DECISION DELEGATED TO HEAD OF PLANNING

Application No: H02-0522-25 **Applicant:** L Adrian
Proposal: Demolition of existing rear structure and erection of single storey rear extension, creation of Juliet balcony, erection of new front porch, internal alterations & erection of single storey pool house with indoor pool
Location: 3 Railway Cottages Martins Road Crowland
Terminal Date: 3rd October 2025

CASE OFFICER ASSESSMENT

FIRST FLOOR, PROPOSED PLAN,
SCALE 1:50

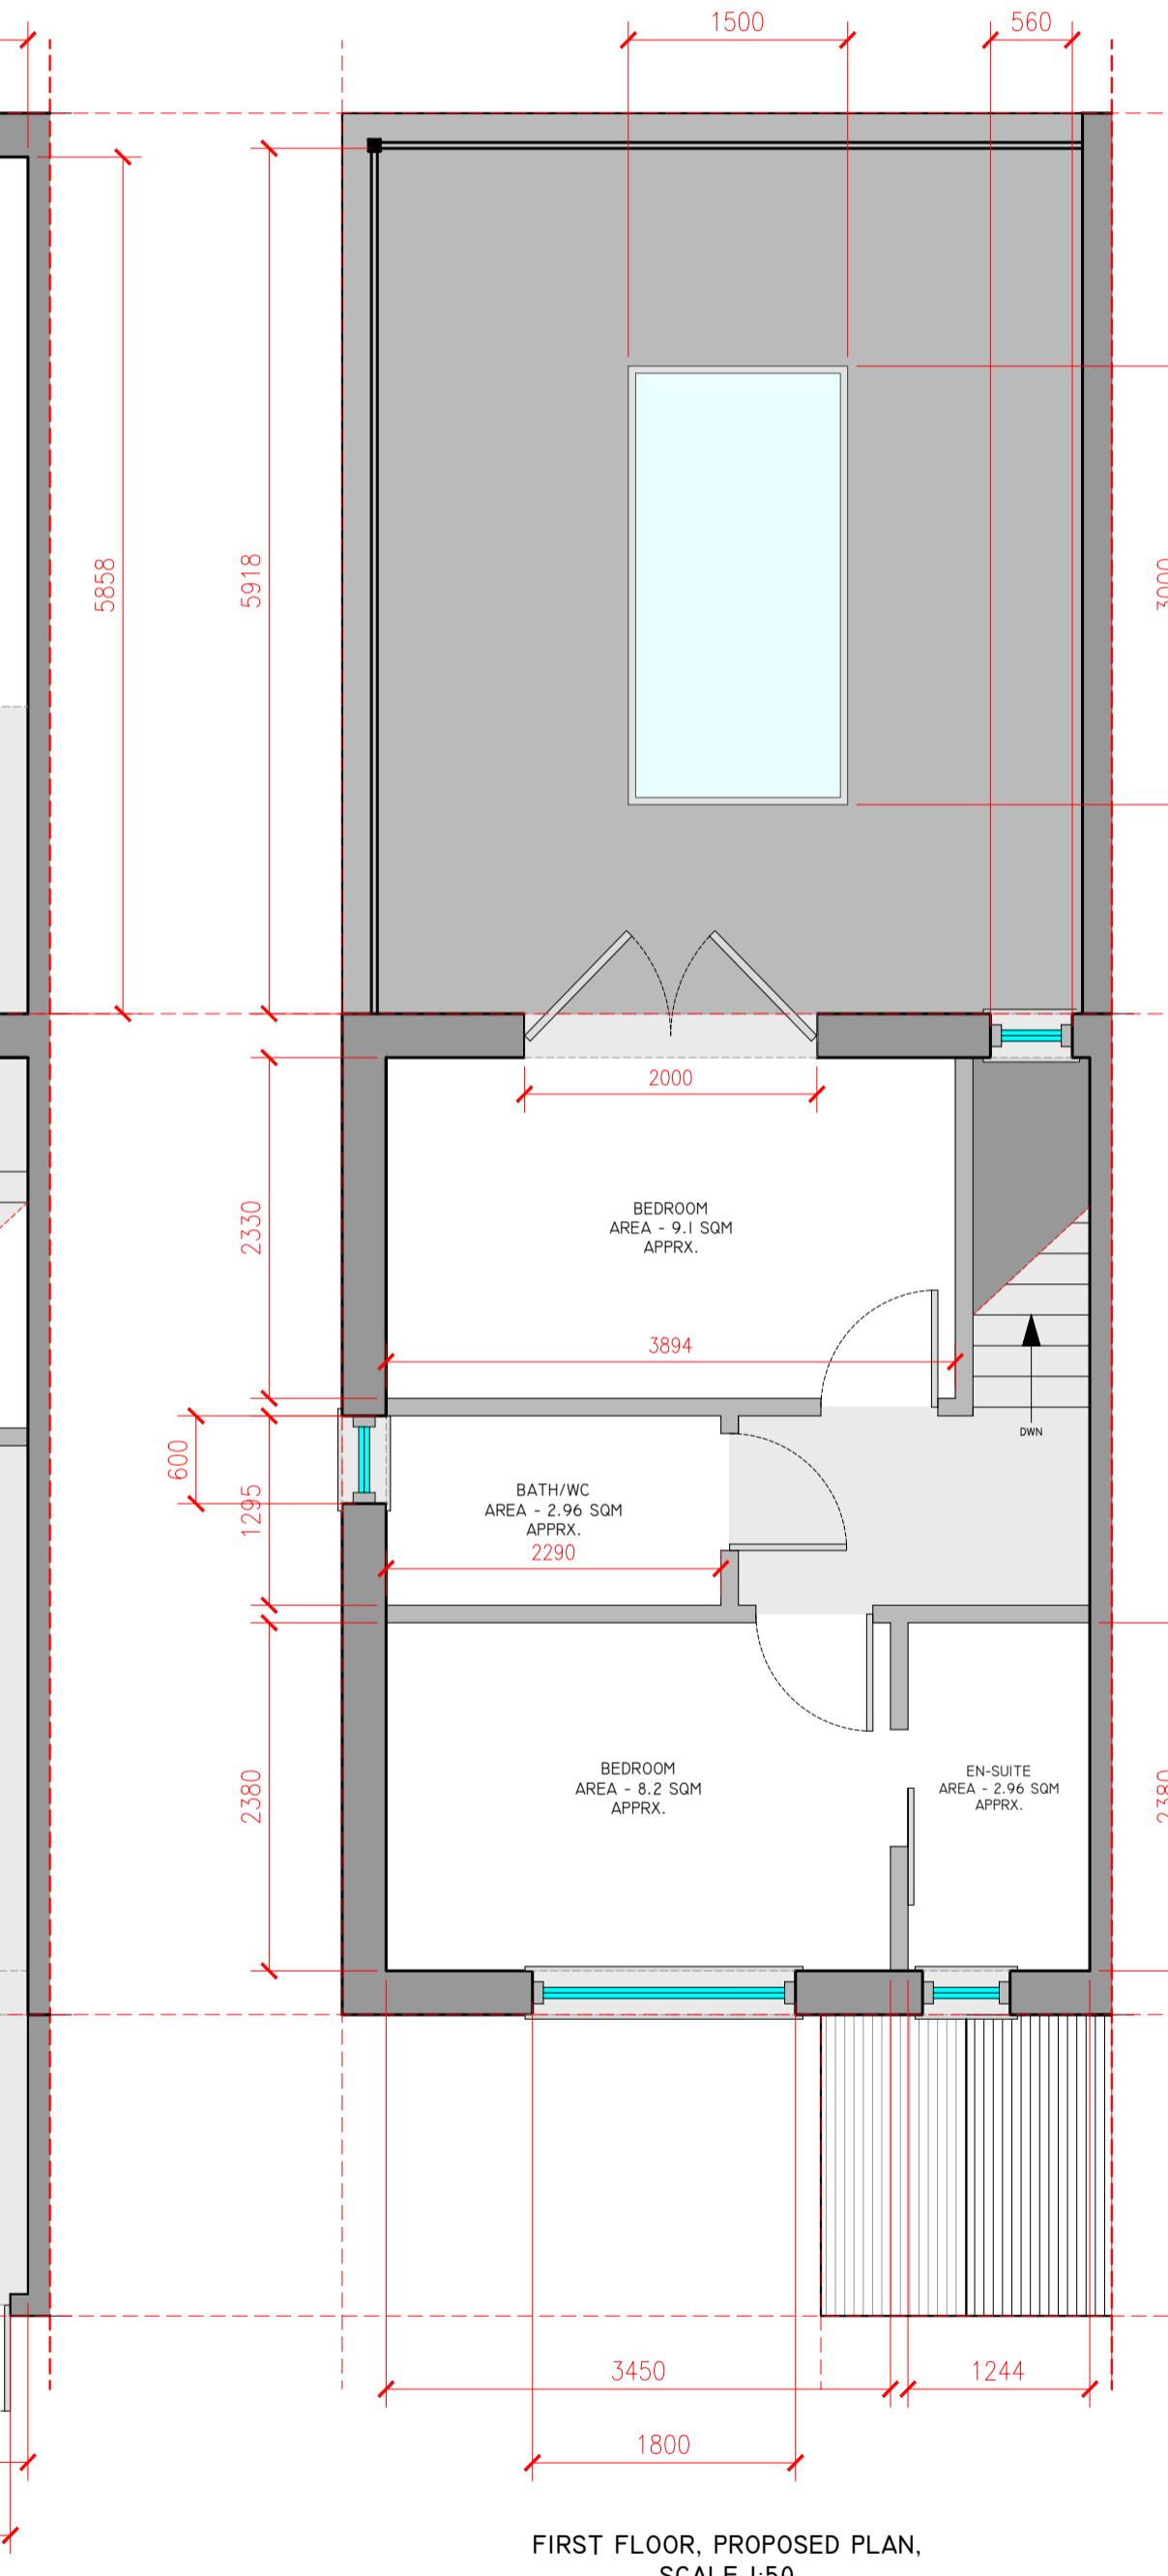
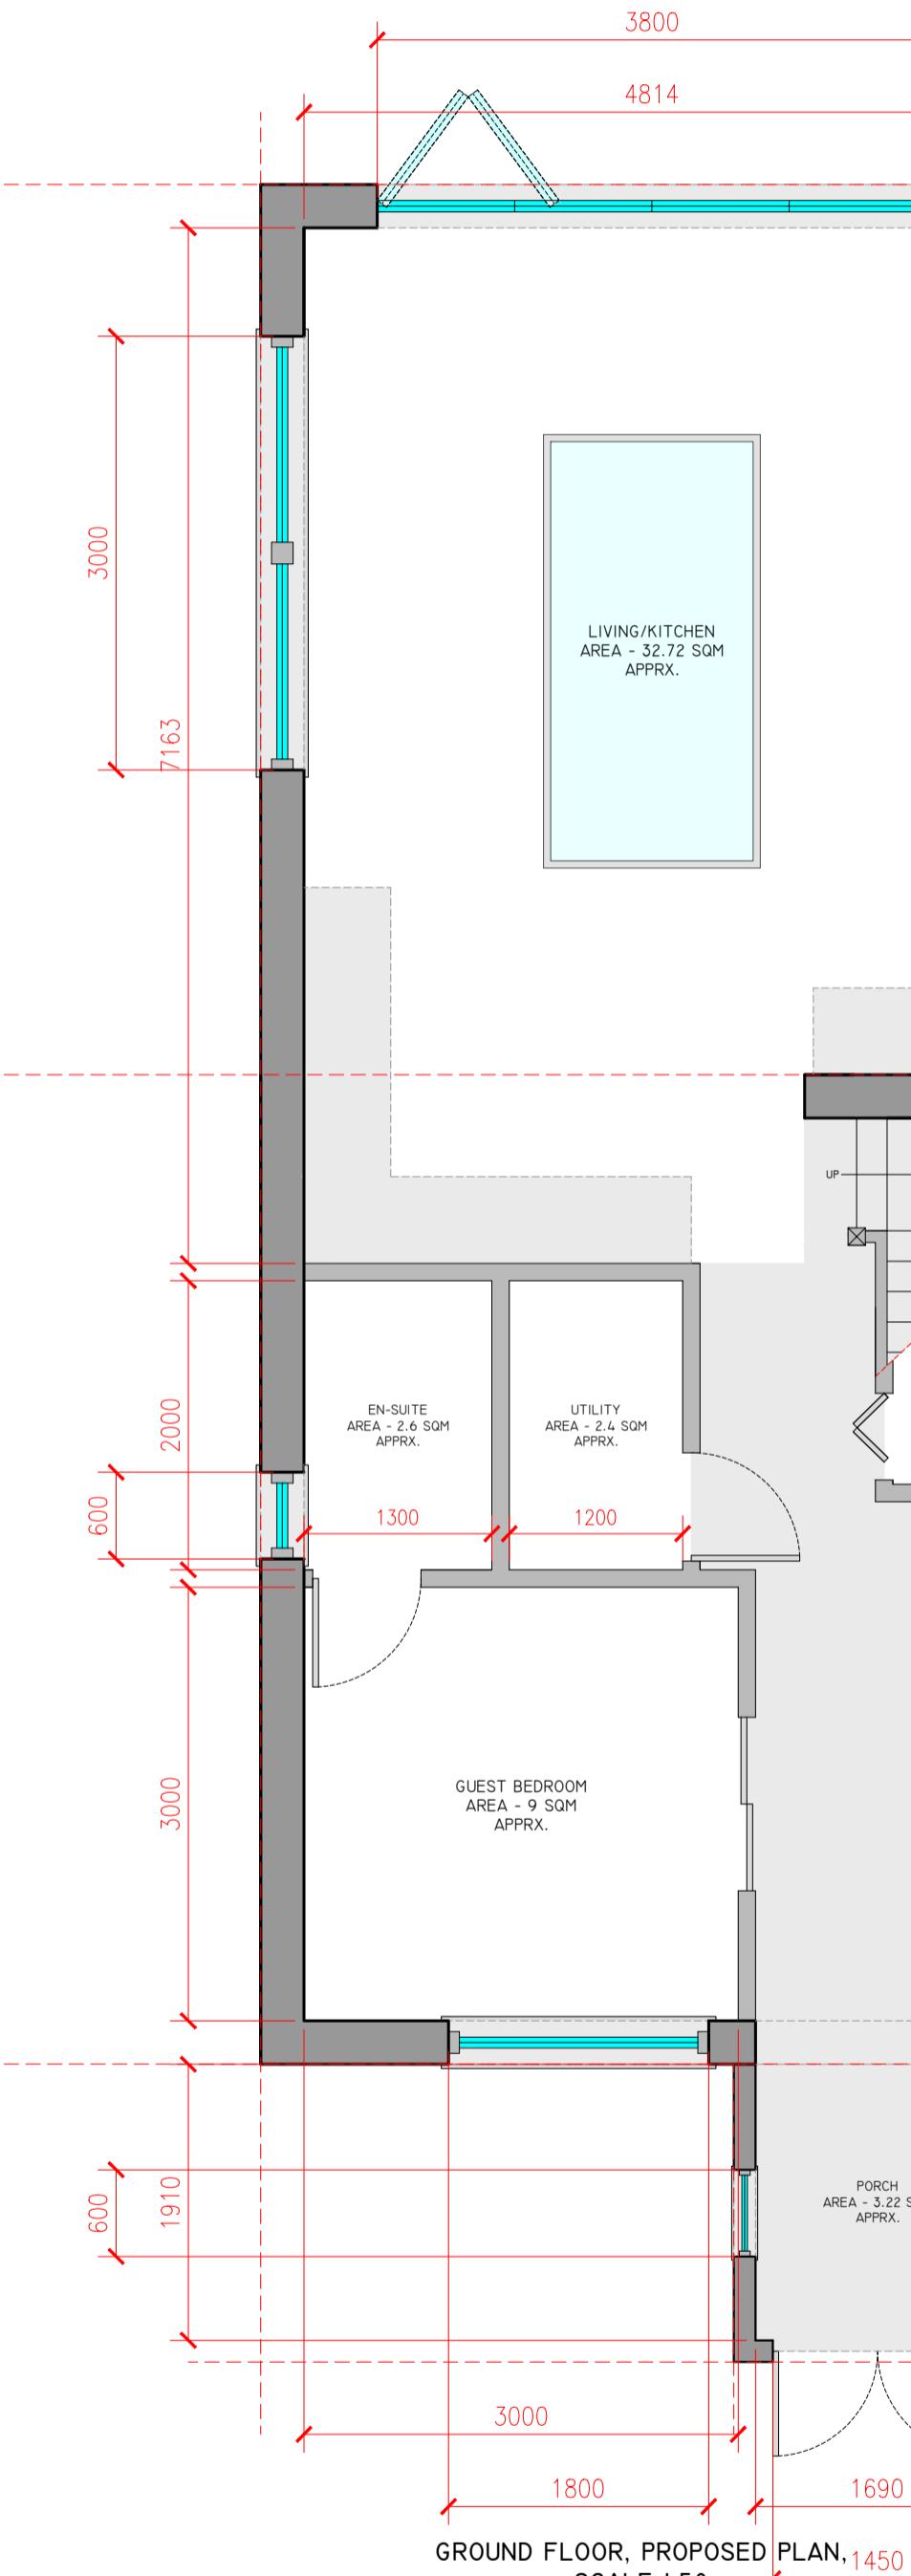
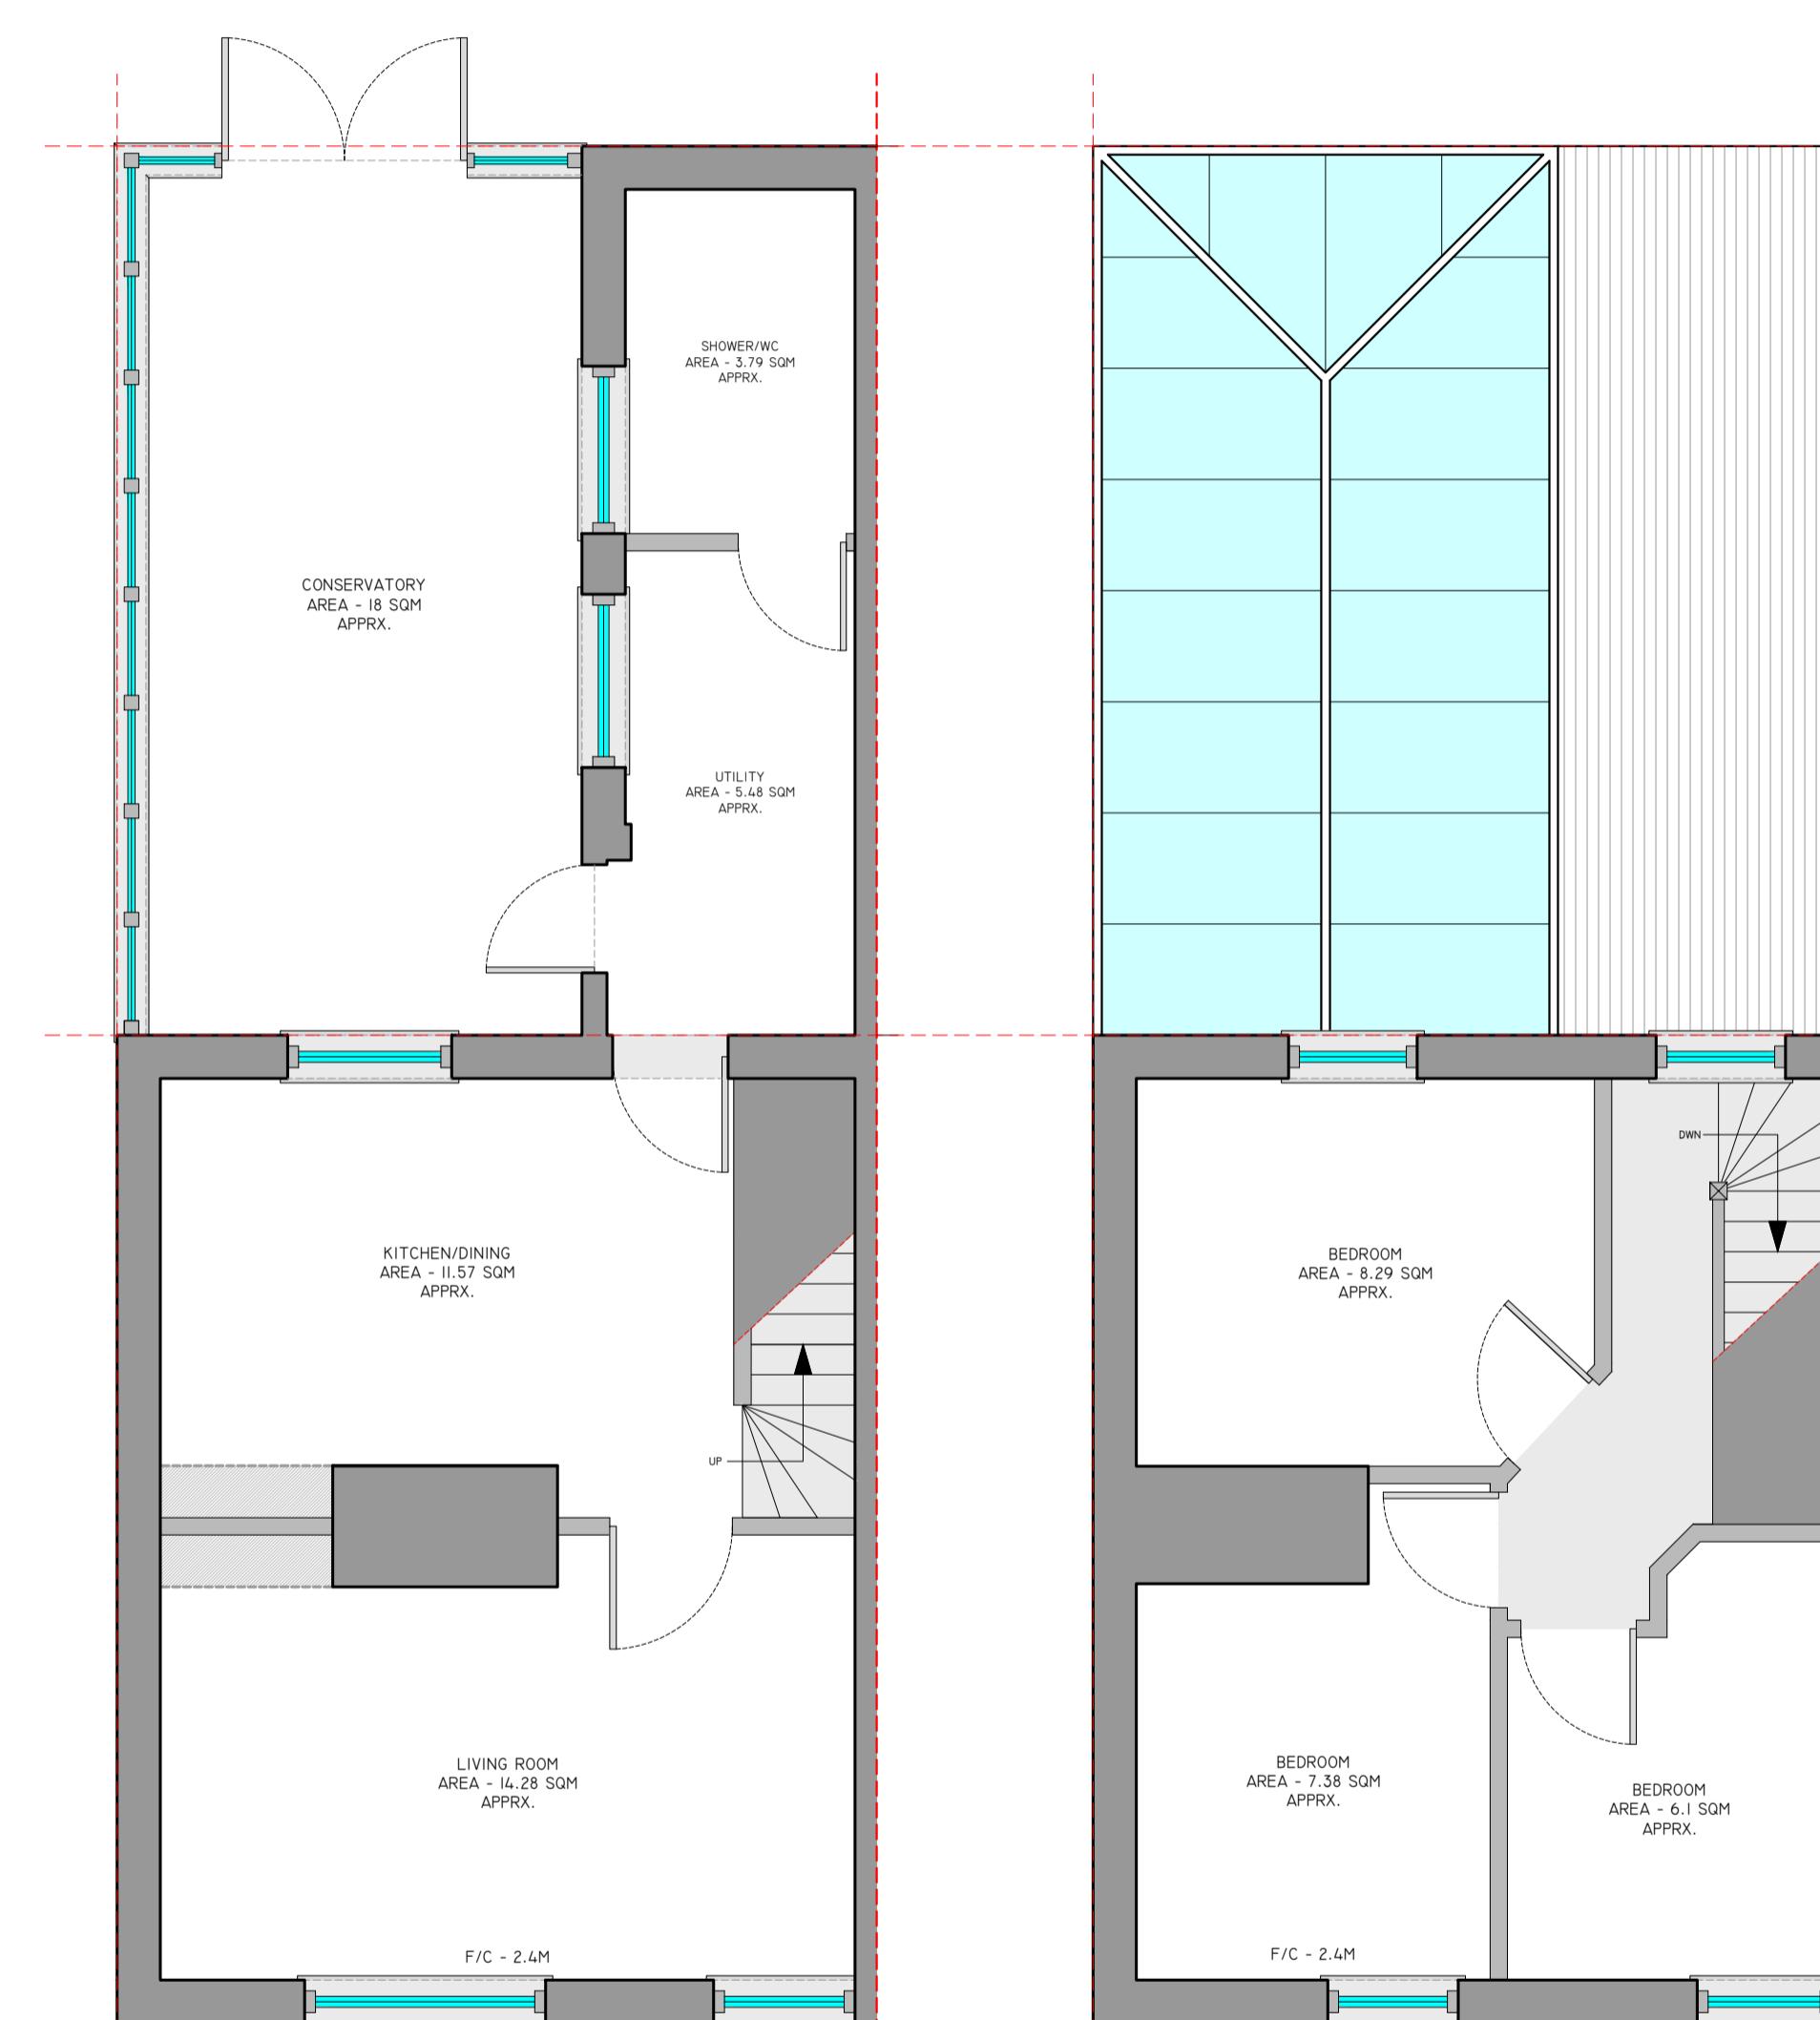
There would also be a Juliette Balcony on the rear elevation serving the first floor rear bedroom. Whilst this may not be common in the area, as it is to the rear and thus not visible from the highway this is considered to be acceptable in this instance.

In regard to overlooking, the rear extension features no side elevation windows and only has one bi-fold door to the rear elevation. If anything, this would be a reduction in overlooking potential as the existing elevations show a conservatory meaning there would be less windows that could provide views over into neighbouring sites. Notwithstanding this, concerns were raised initially in relation to the potential overlooking through the proposed flat roof terrace and opening via a set of French Doors.

To combat this, amended plans were submitted which removed this opening and was replaced with a Juliet Balcony. The potential views from this window would not provide any significant extra material loss of privacy due to the windows currently along the rear elevation. In a similar light there
